From: Chris Pirone
To: JF@portlandmaine.gov
Date: 4/30/2014 9:55 AM
Subject: 421 Warren ave

Initial Fire Comments:

PROJECT PH WARREN AVENUE, LLC
SHEET TITLE SITE LAYOUT AND UTILITY PLAN

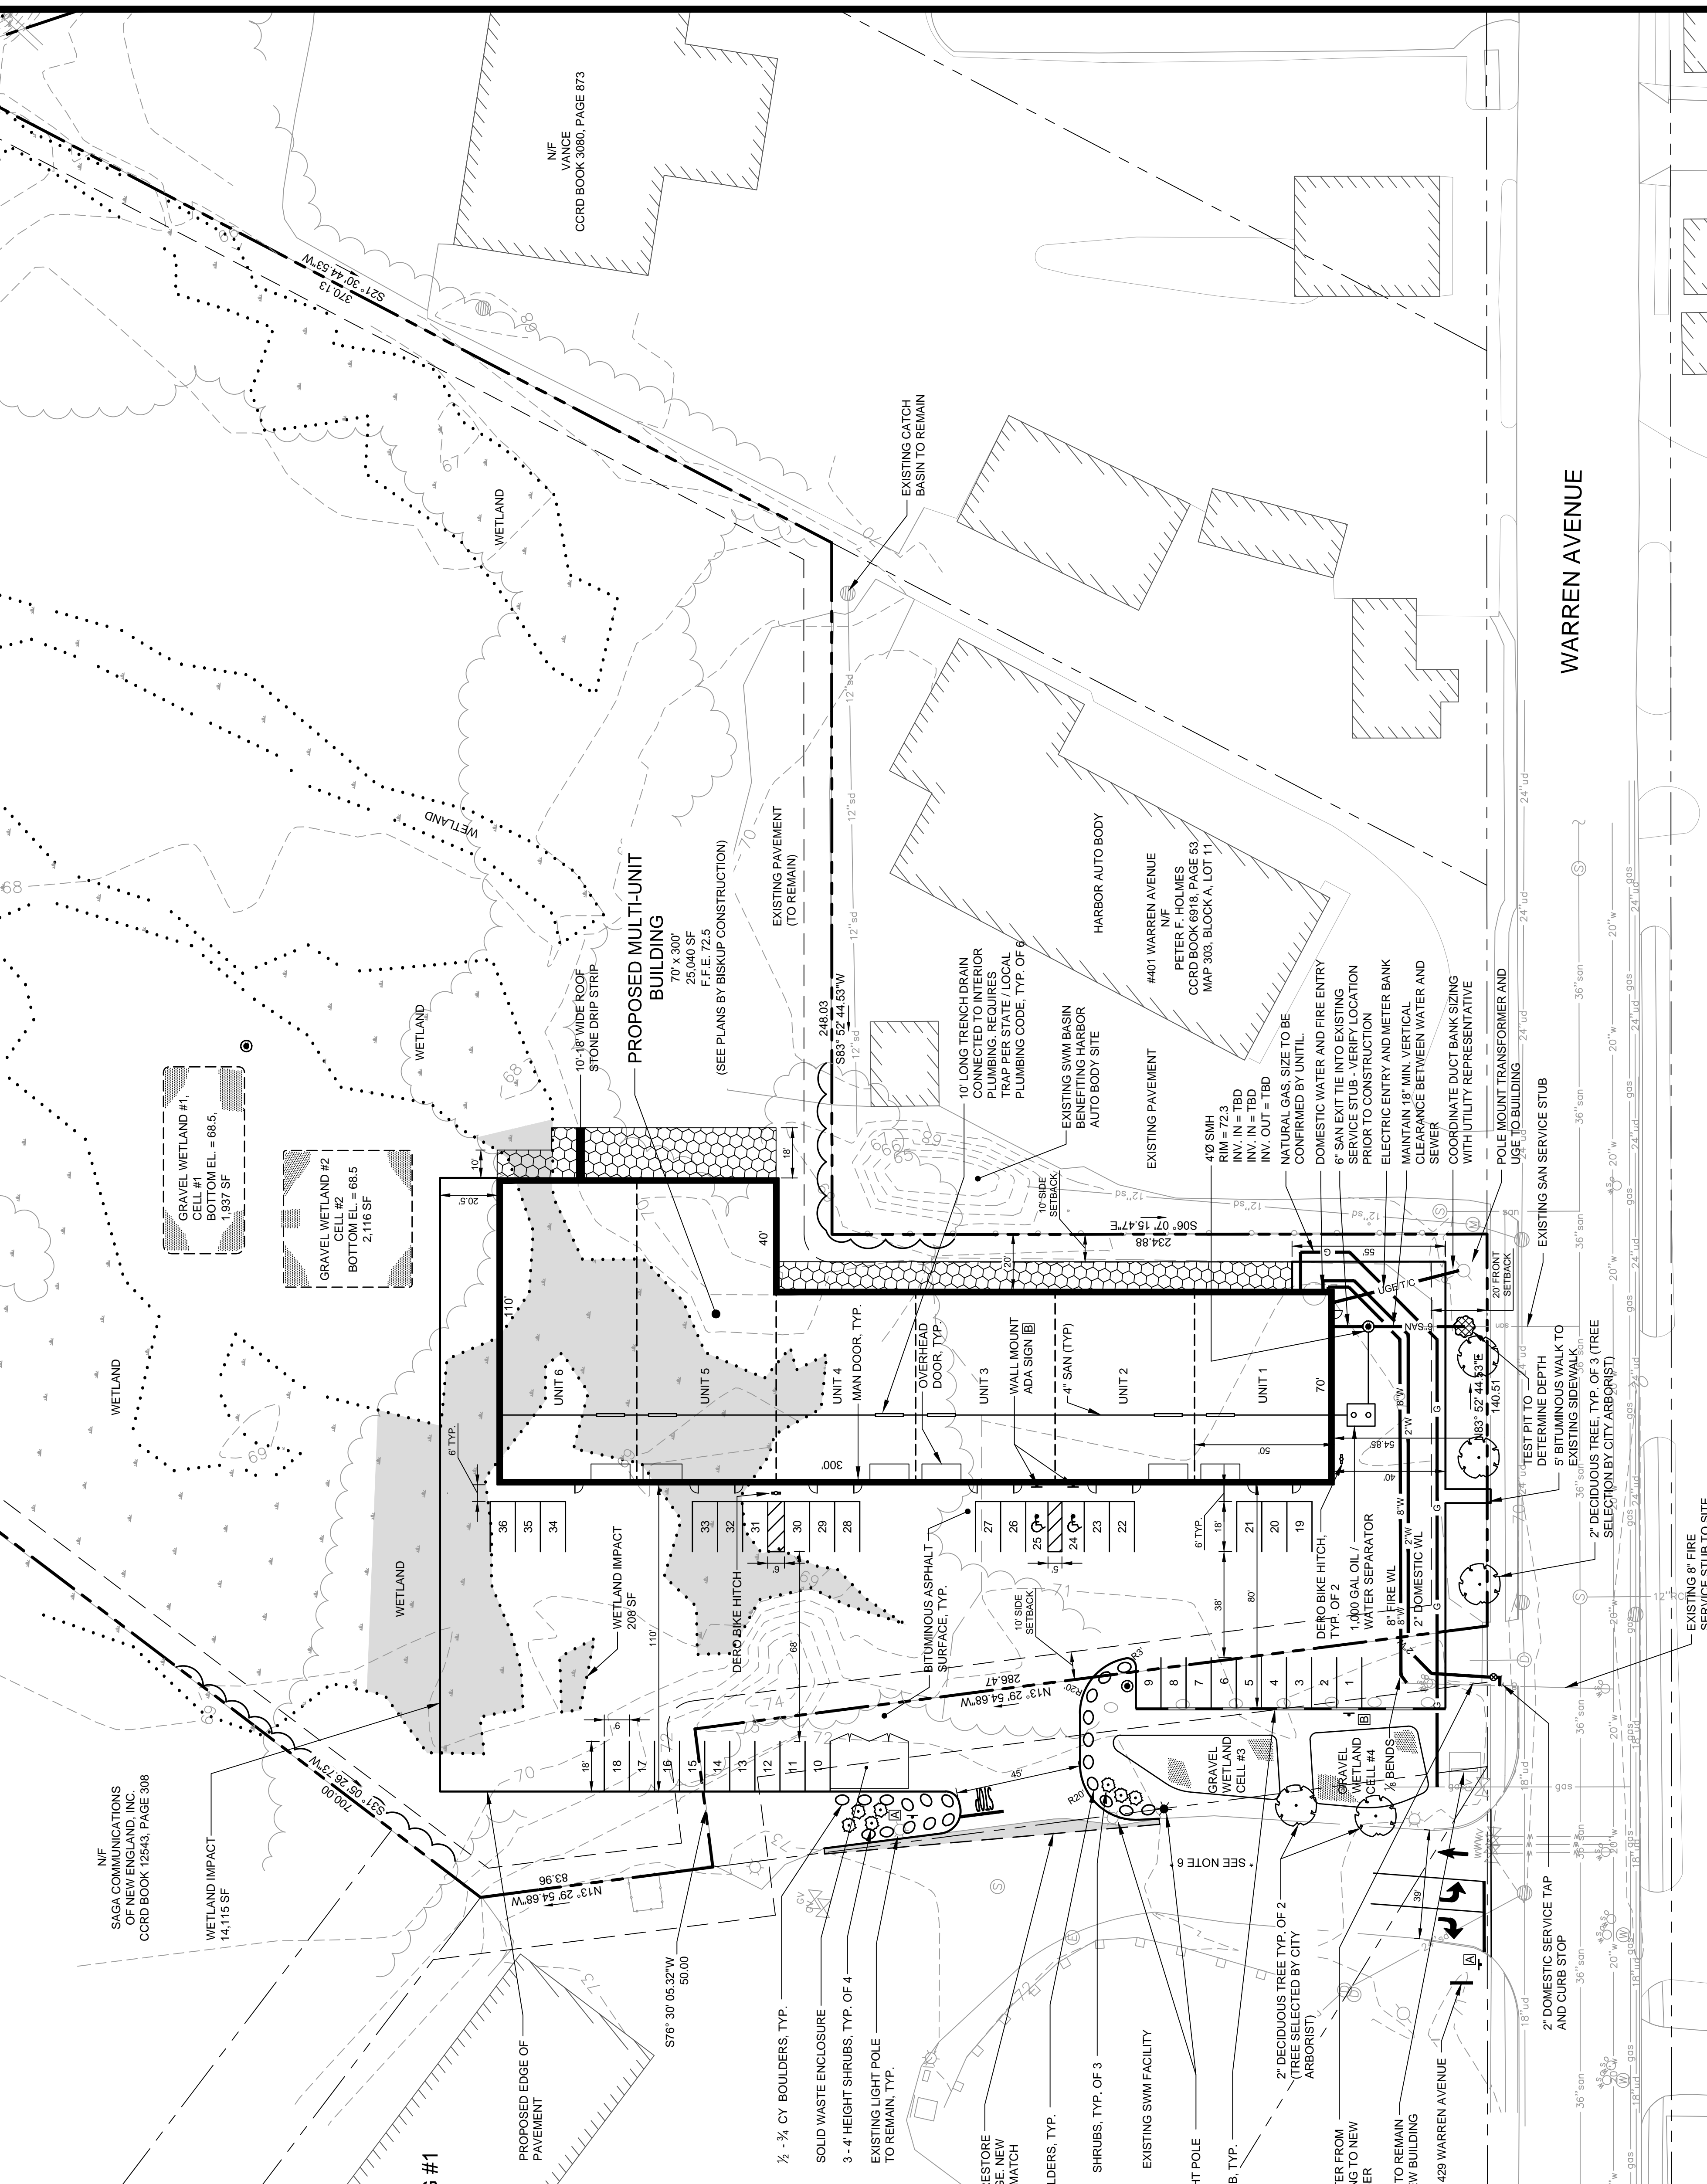
Access looks good as aisle widths are presently 38'.
Is the 20' access at the rear of the building being proposed for the Fire Department?

It appears a sprinkler system is being installed.
The fire department connection for the sprinkler system will need to be located on the front of the building and will need to have a fire hydrant within 100' of the connection but no closer than 40'.

A private fire hydrant may need to be installed per NFPA 1 on site.

Exits from the building shall continue from the building onto the site with clear walkways for the occupants to stage if an emergency happens in the building.
